# **M3 Junction 9 Improvement**

**Scheme Number: TR010055**

## **5.1 Consultation Report Appendix E - EIA Scoping**

# **SCOPING OPINION:**

DRAWING TITLE  
FIGURE 2.7 - THE SCHEME: PROPOSED UTILITY DIVERSIONS  
APFP REGULATIONS 5(2)(a)  
SHEET 1 OF 5  
DOCUMENT REFERENCE 6.2

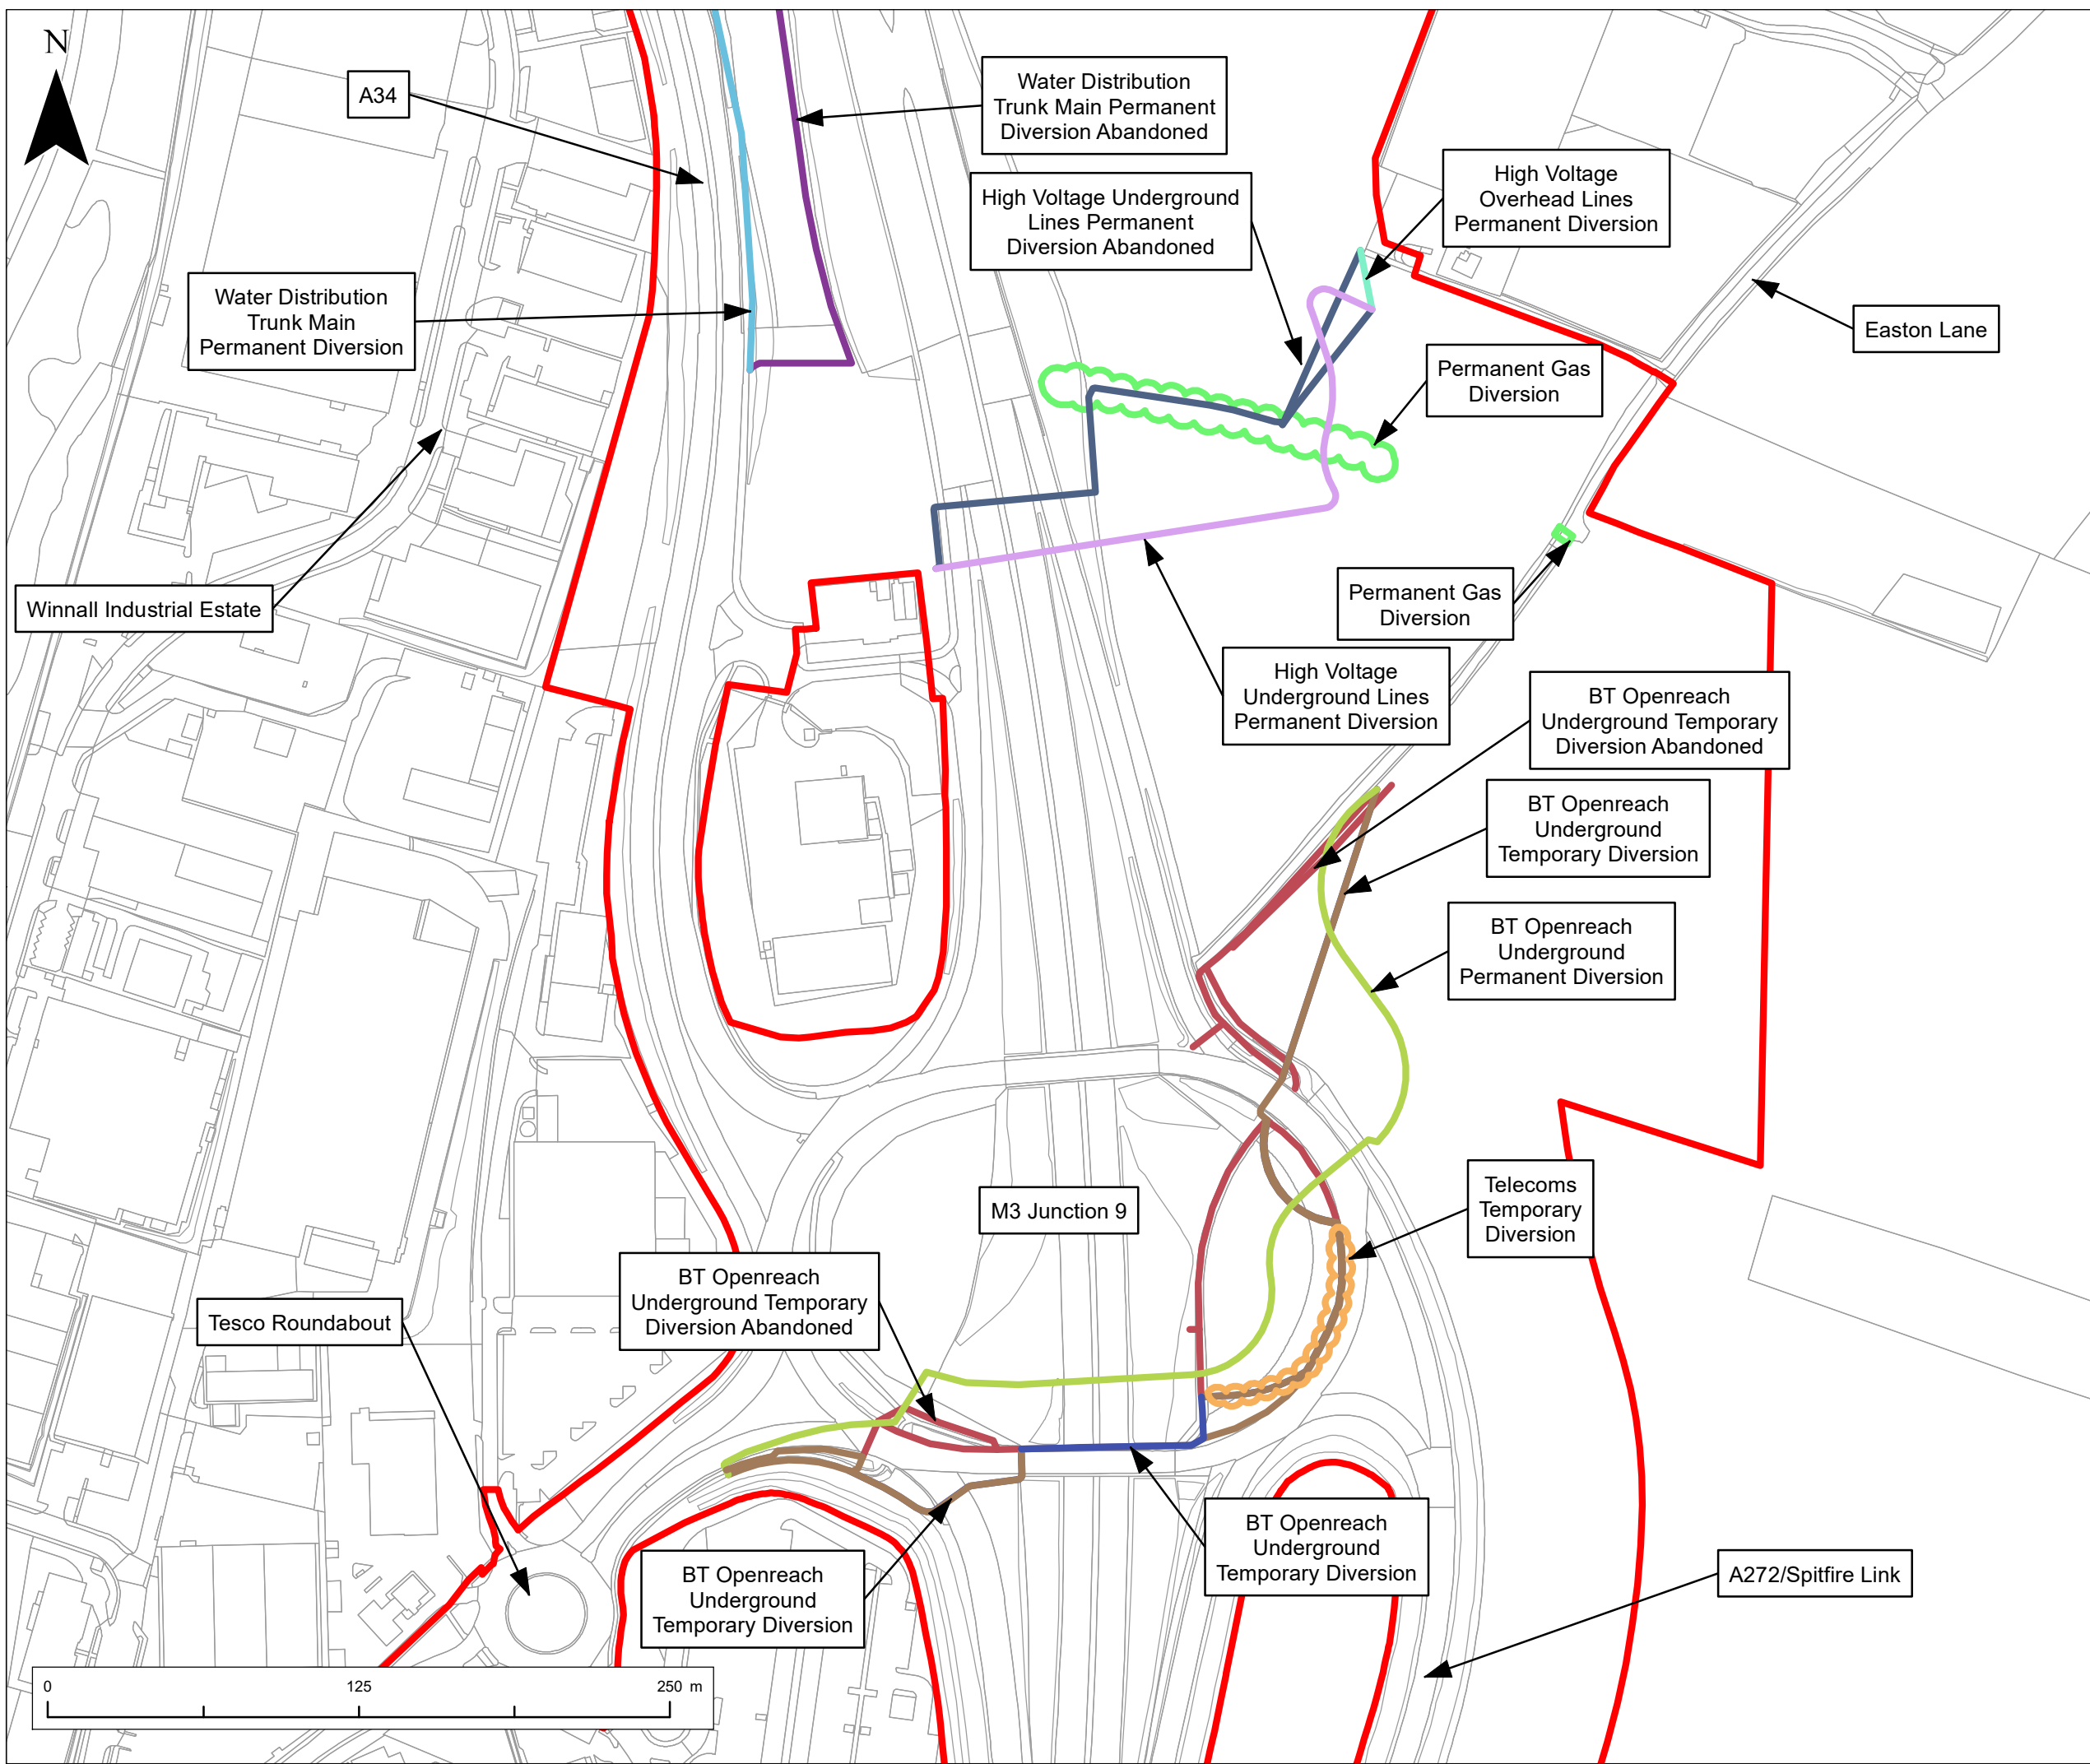
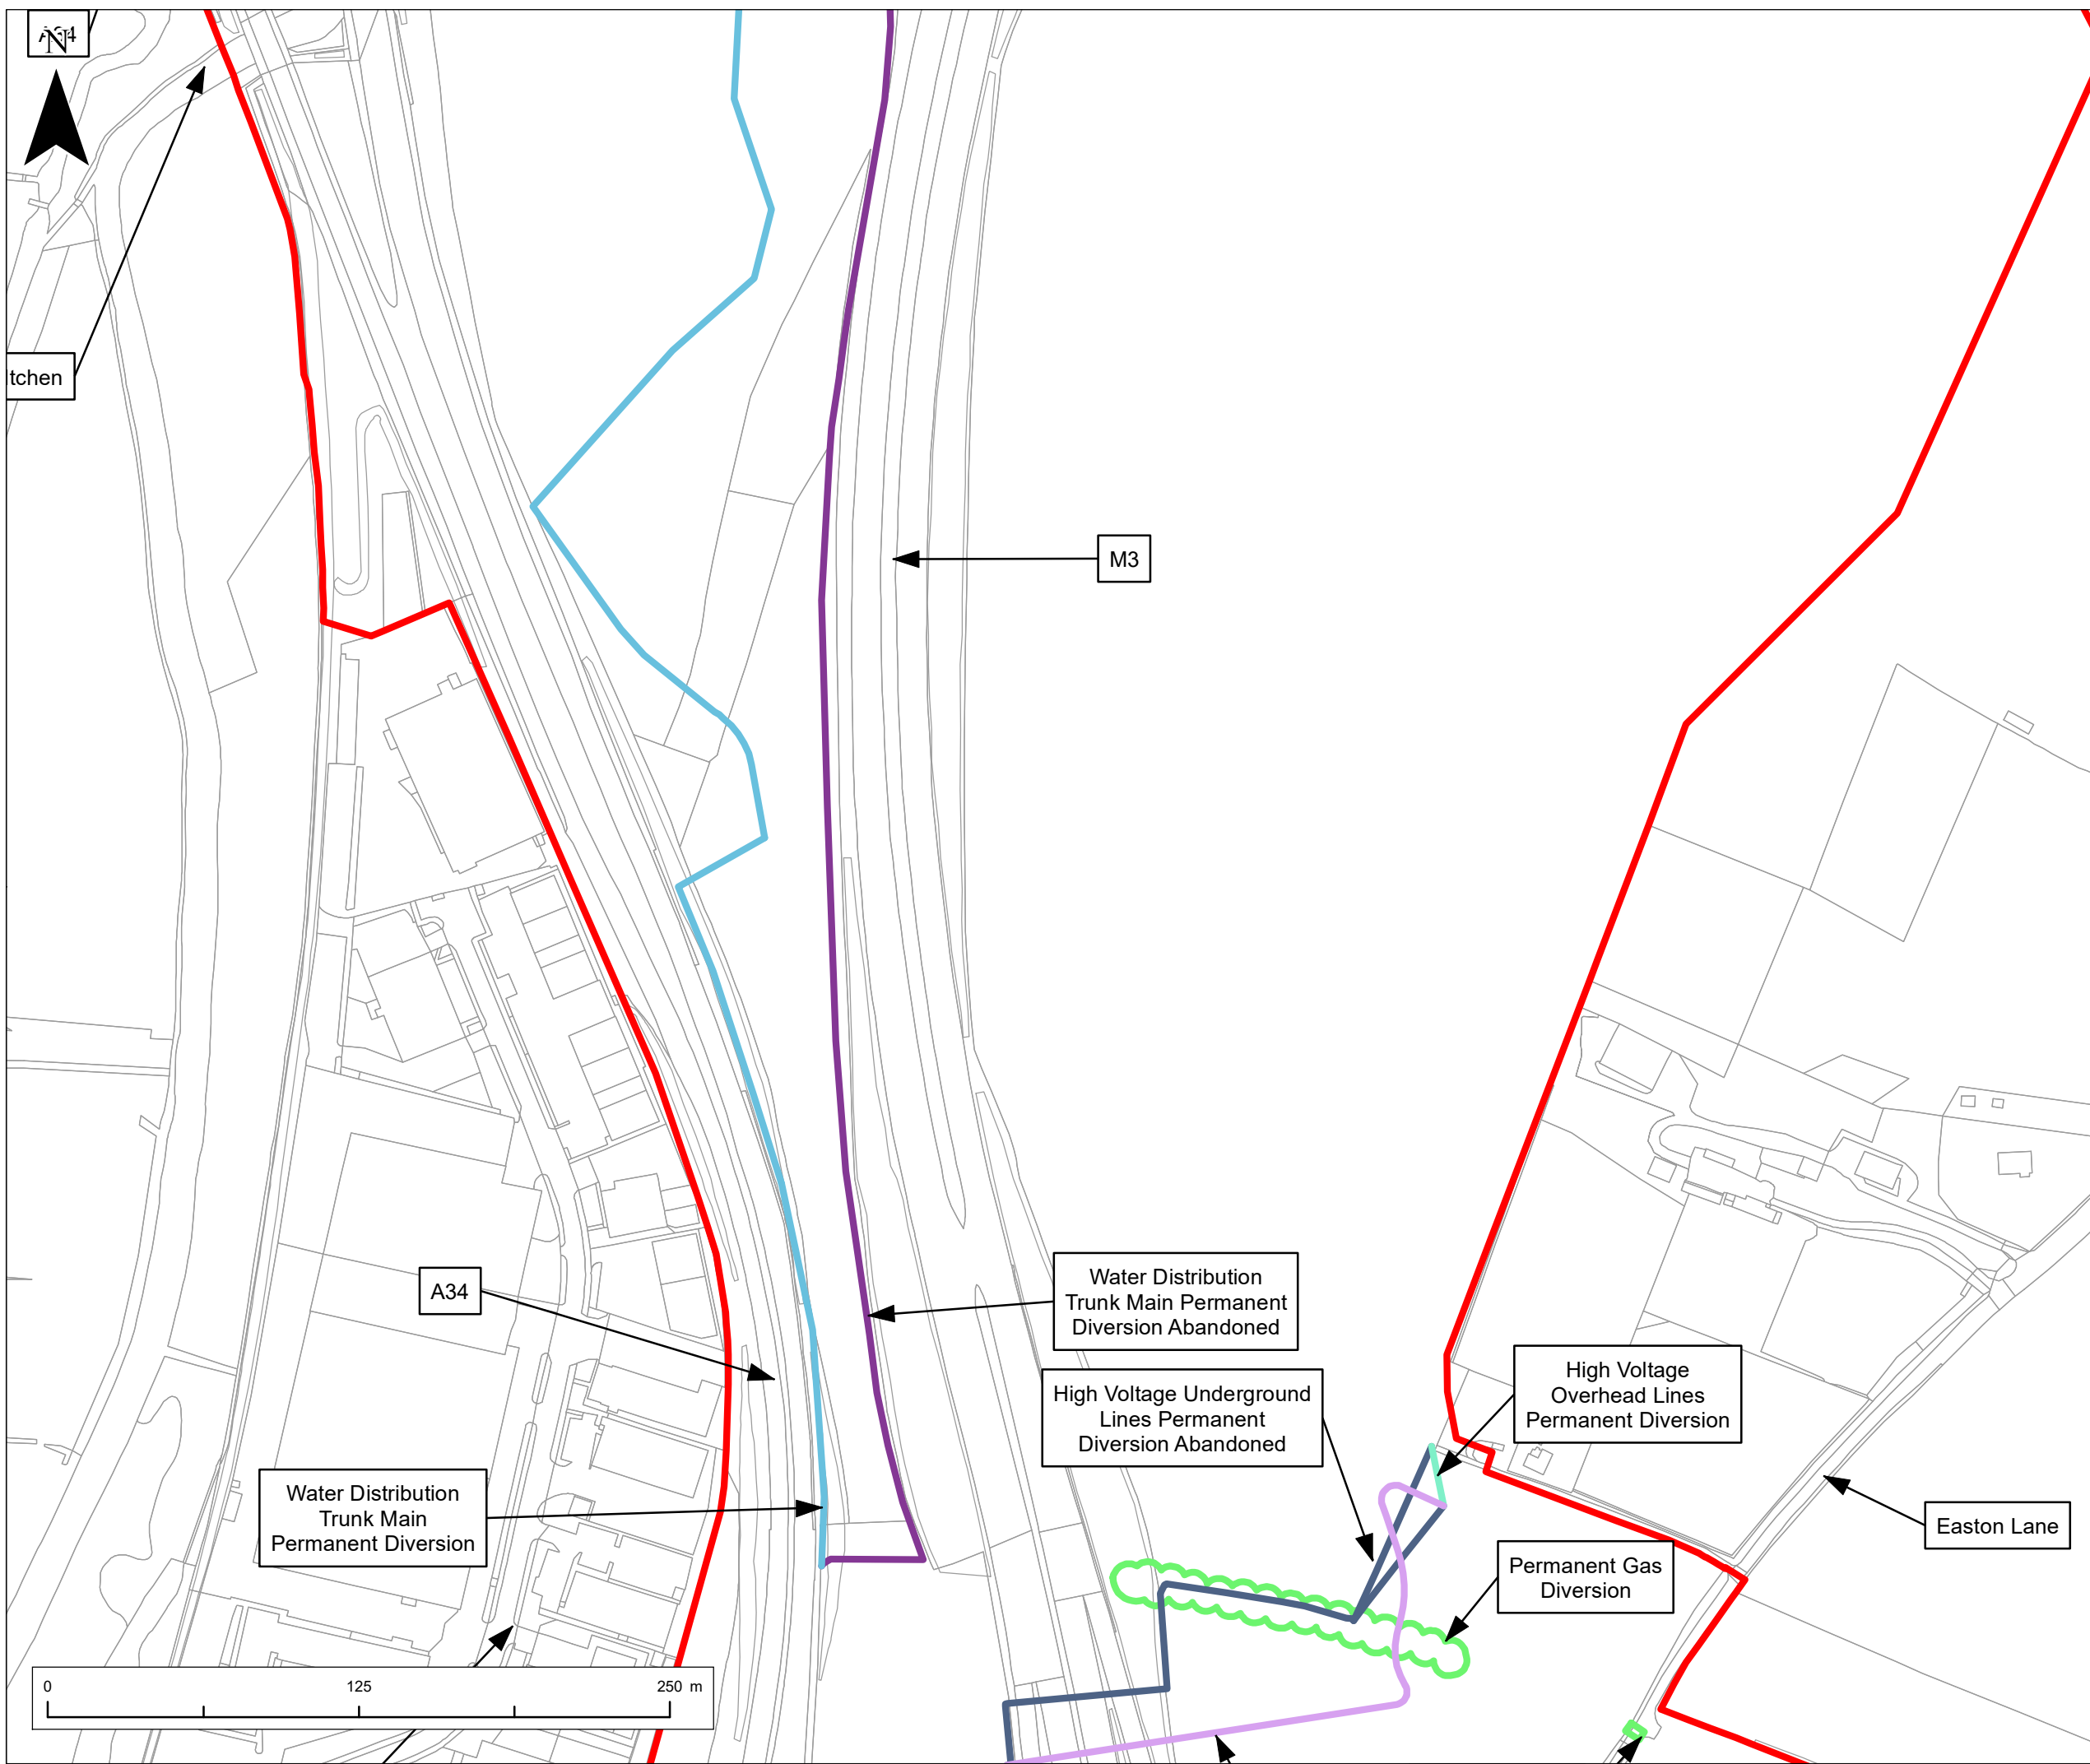
- 2.3.4 It is considered that the Proposed Development may require the diversion of various cables and utilities. This will necessitate associated ground moving activities, such as excavation and the establishment of temporary work areas. However, limited further information is provided on any diversions. The Applicant should ensure that the ES provides specific detailed information on this element of the Proposed Development, including plans to identify the diversions, and should ensure that any assessment is consistent with works specified within the dDCO.
